CITY OF ALBUQUERQUE

January 2, 2024

Re: 2900 Central
2900 Central Ave. SE
Traffic Circulation Layout
Engineer's Stamp 12-01-23 (K16-D009A)

Based upon the information provided in your submittal received 12-20-23, the above referenced plan cannot be approved for Building Permit until the following comments are addressed:

C502

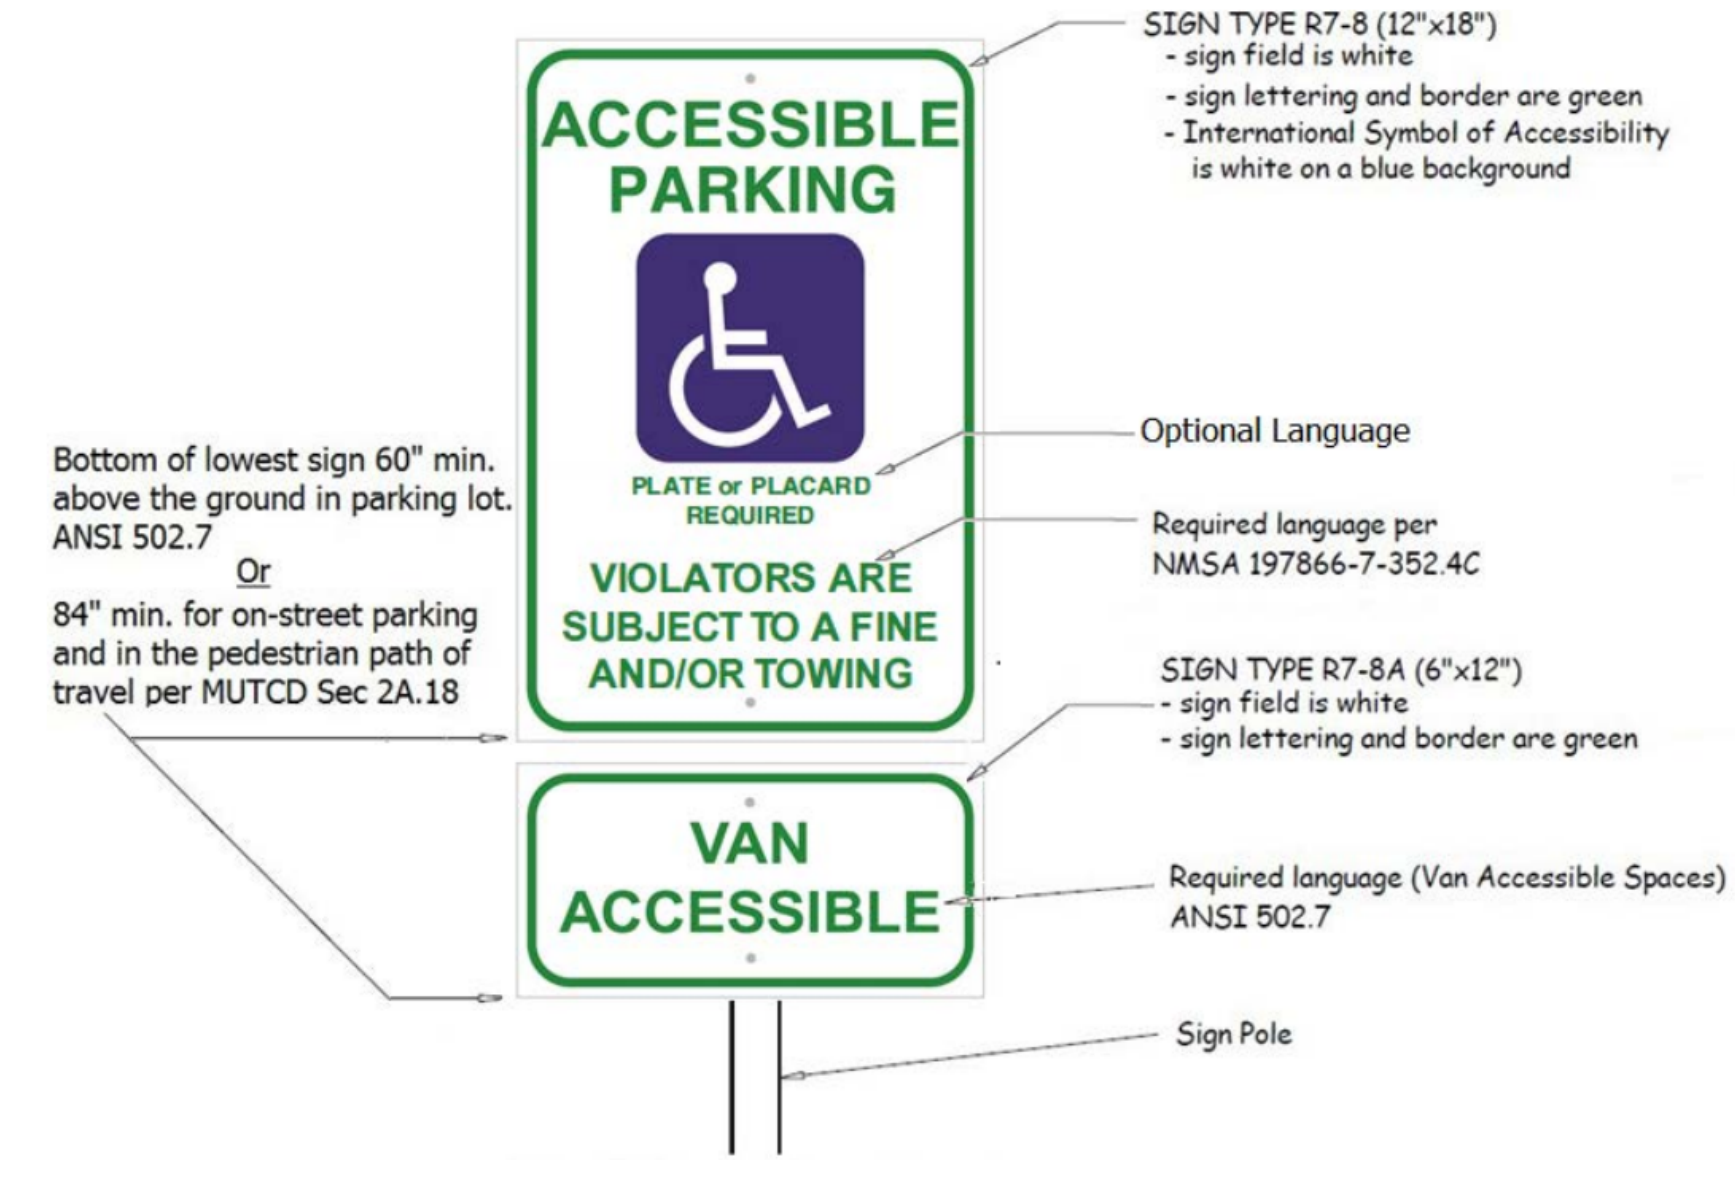
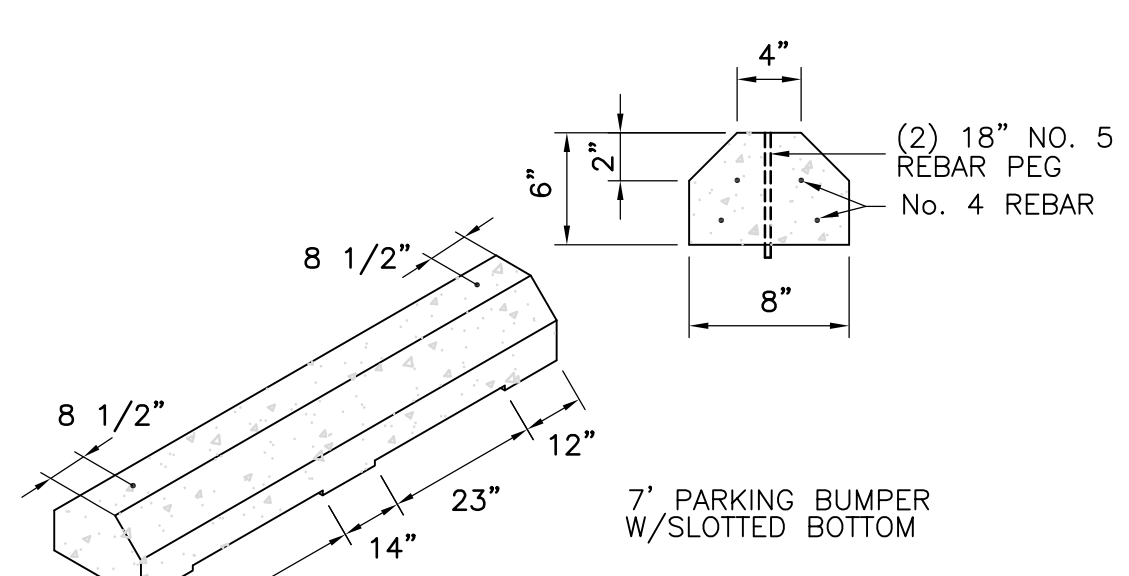
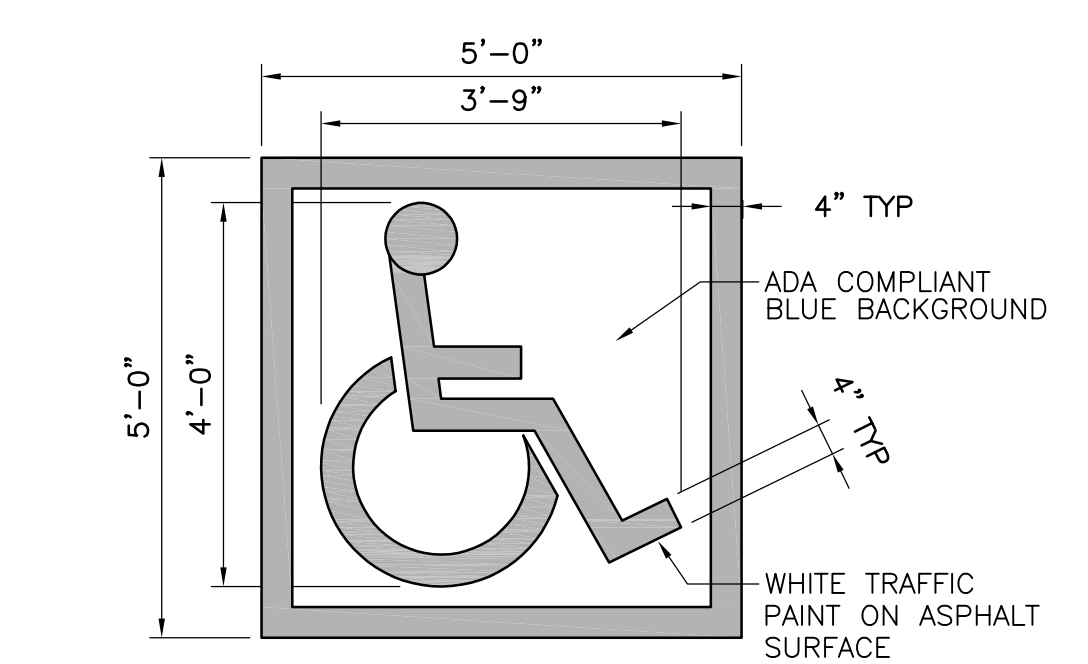
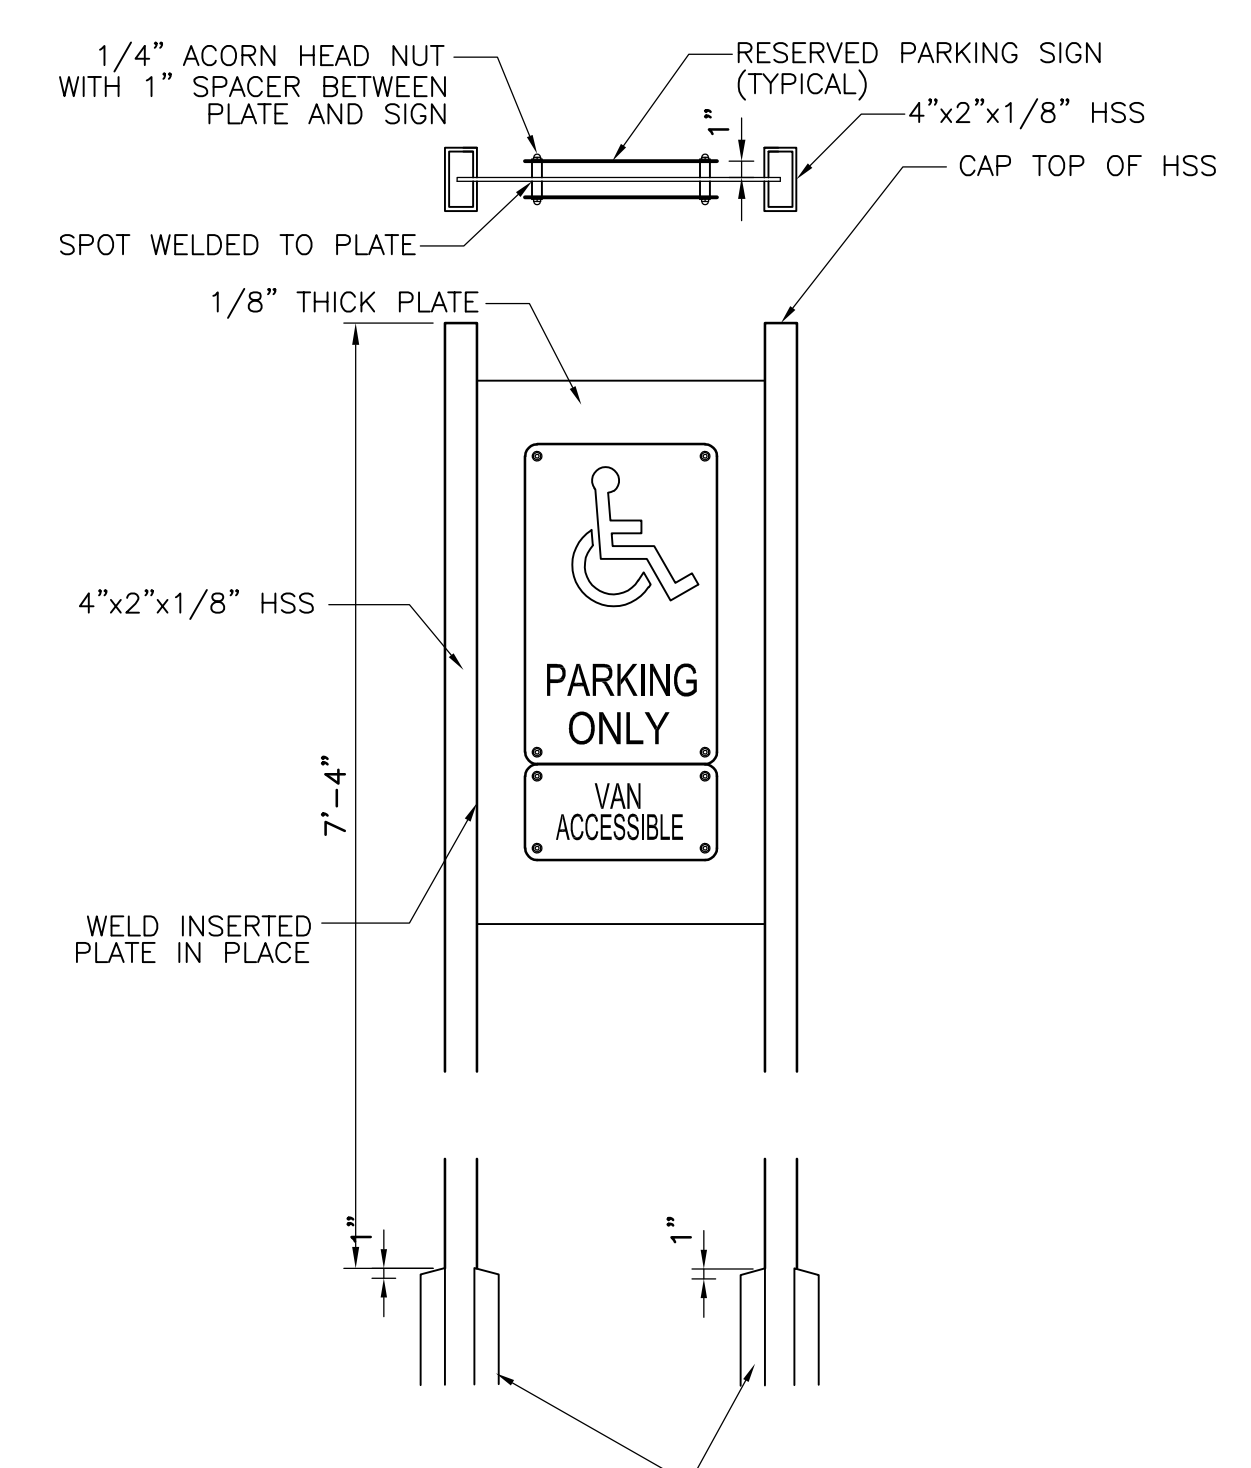
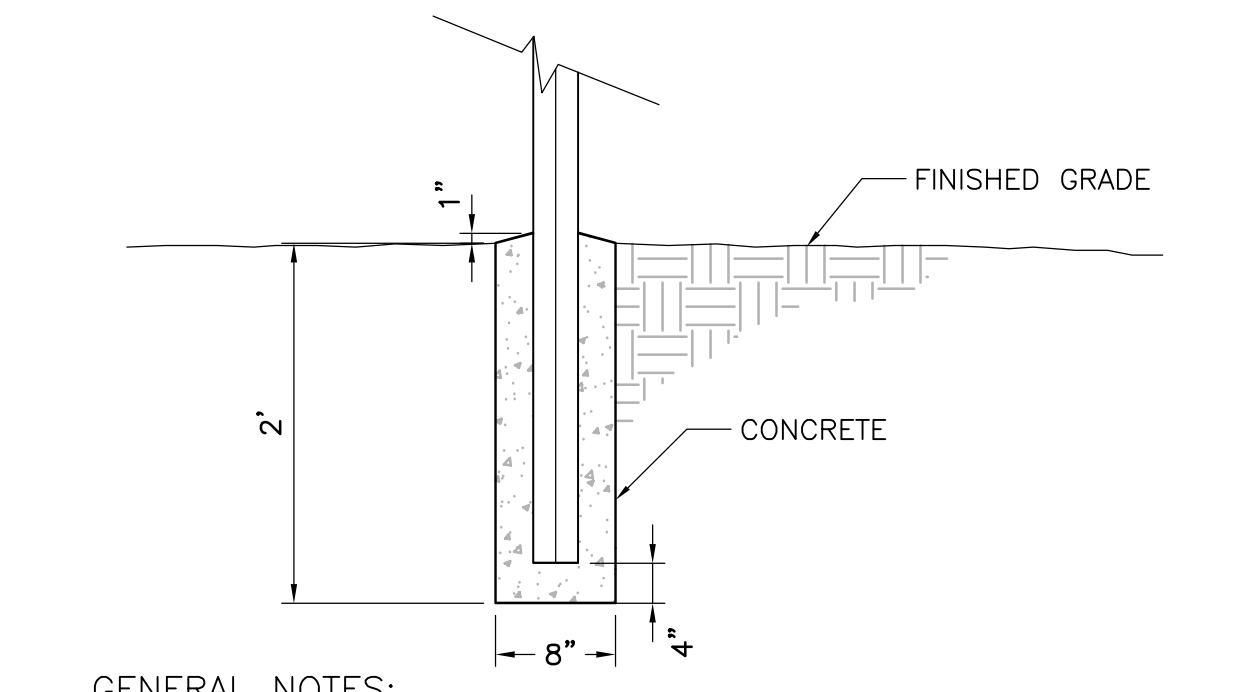
7. Please remove any non related transportation details from sheet C502, such as details E1,2,3,D5, and A5.
8. It appears there are two signs encroaching into right of way, either remove them or a revocable permit is required.
